Re: 23 Ocean Mixed Use  
Level III Final Application Submission

Date: January 25, 2017- Revised

## Construction Management Plan

Off Street Parking Diagram

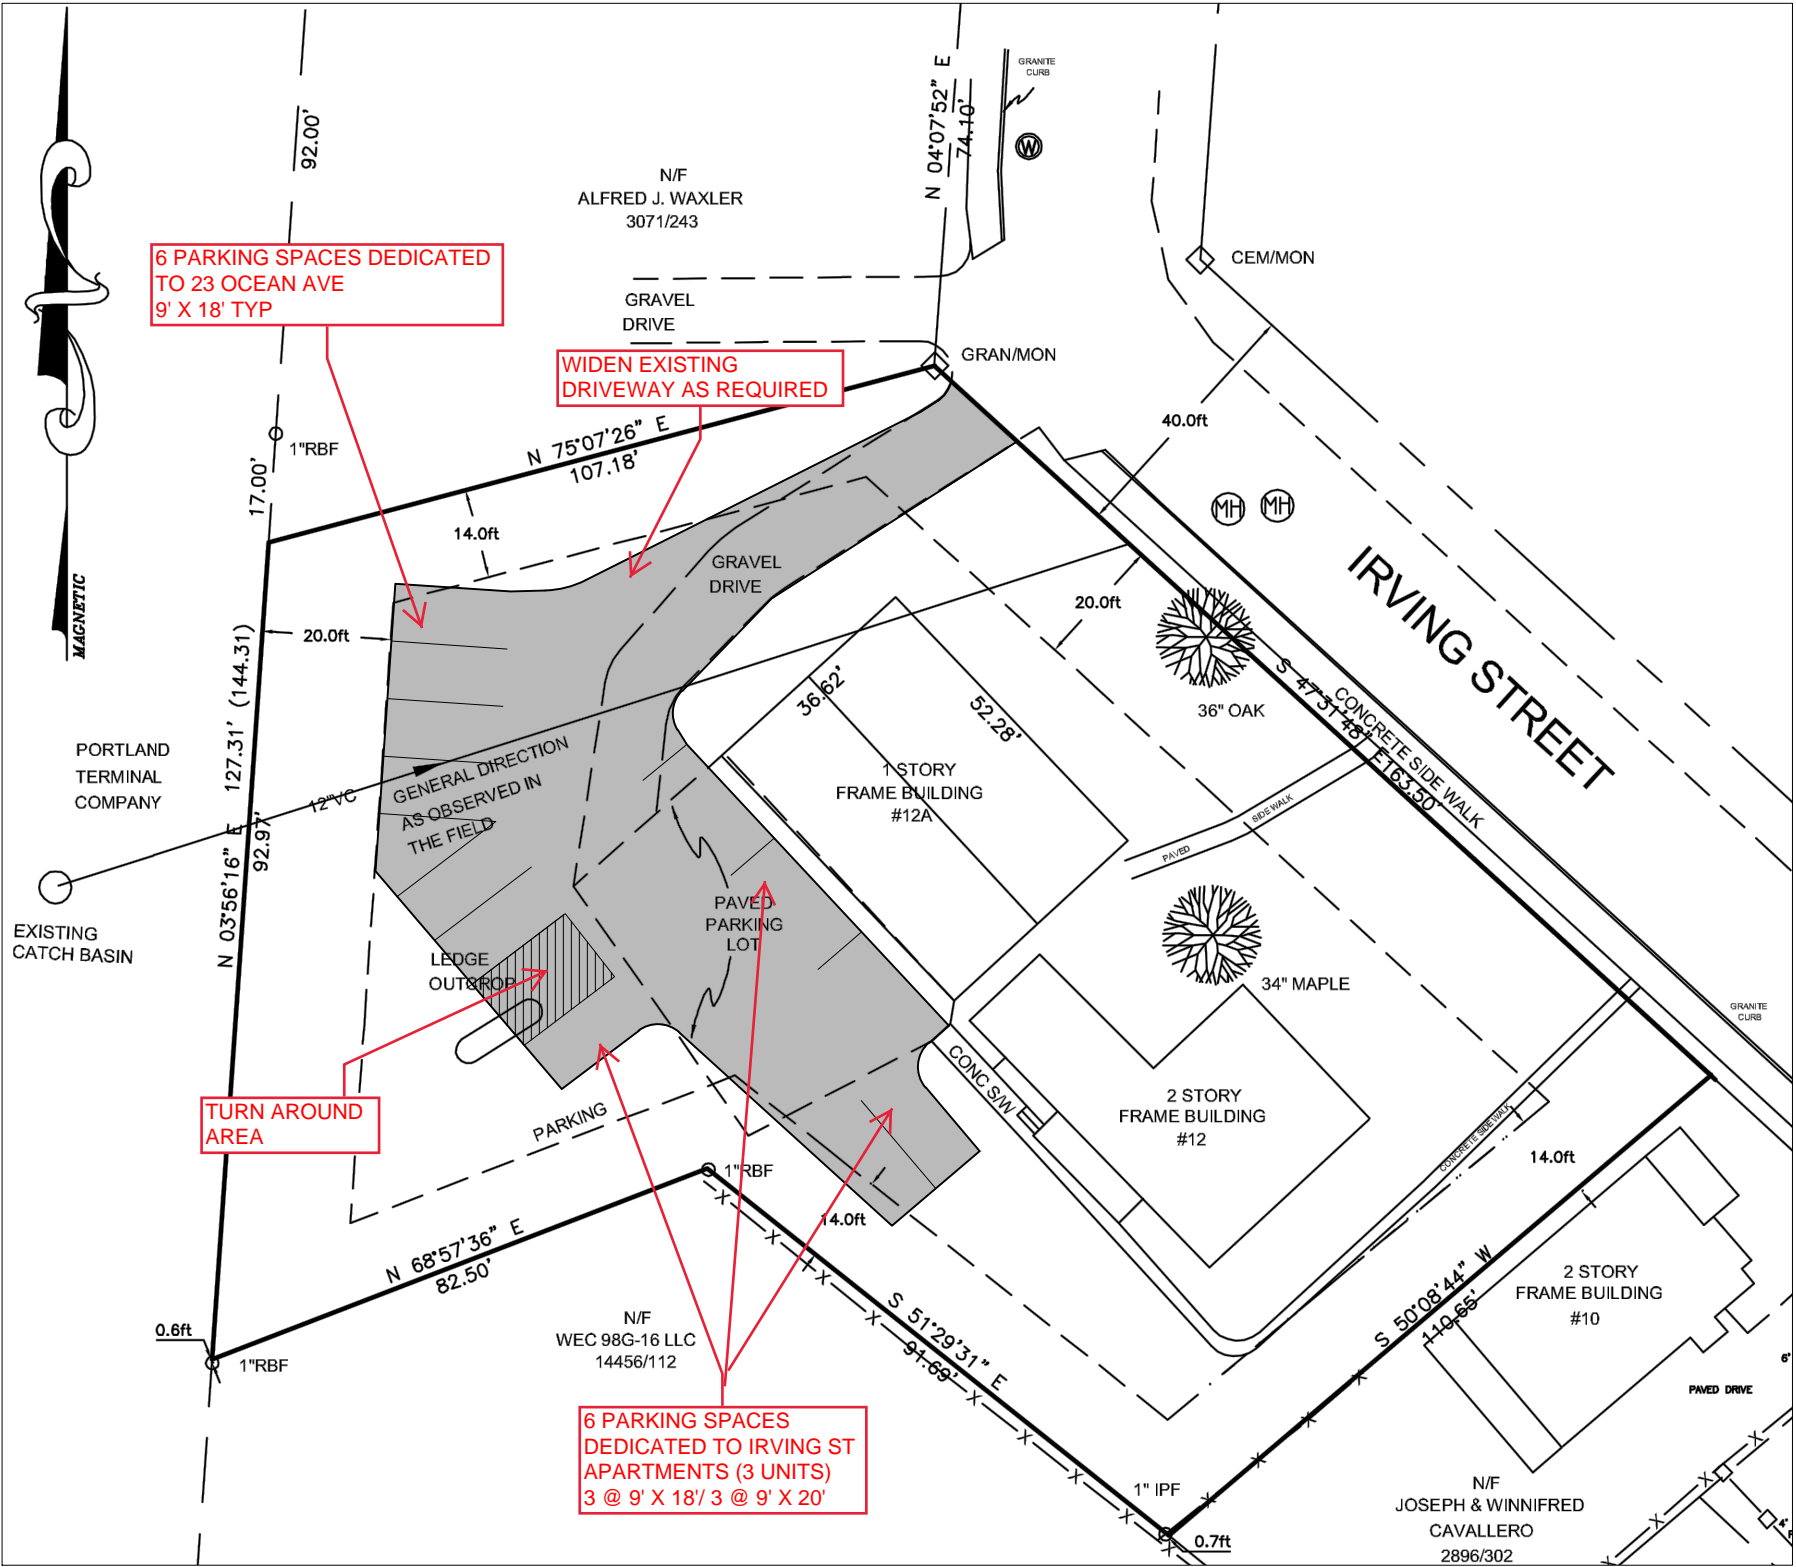
seriously? lease if financial function?
